An
Bord
Pleanála

Inspector's Report ABP-311016-21

Strategic Housing Development

1,221 no. apartments, crèche and associated site works.

1 BLOCK E1/2 EAST ELEVATION
 1 : 200

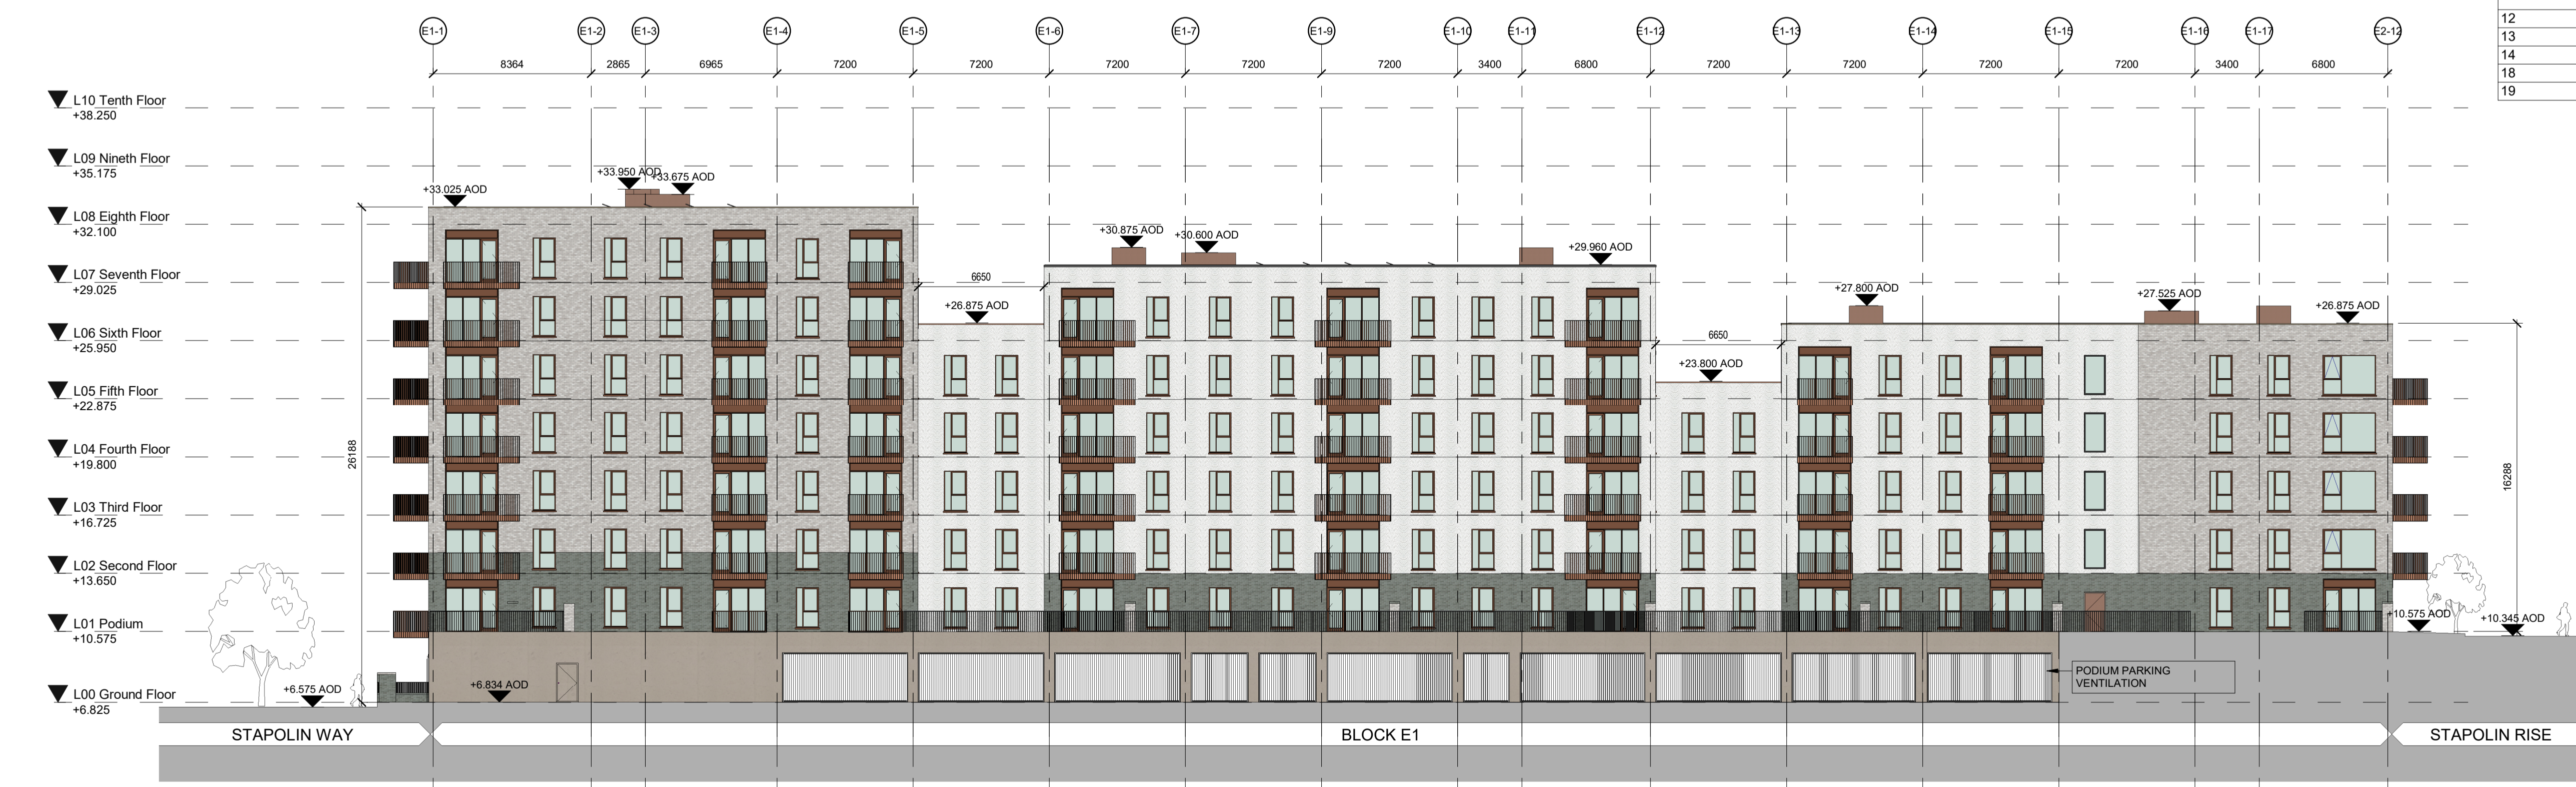
redesign of these balconies may require the reorientation and reconfiguration of block E1.
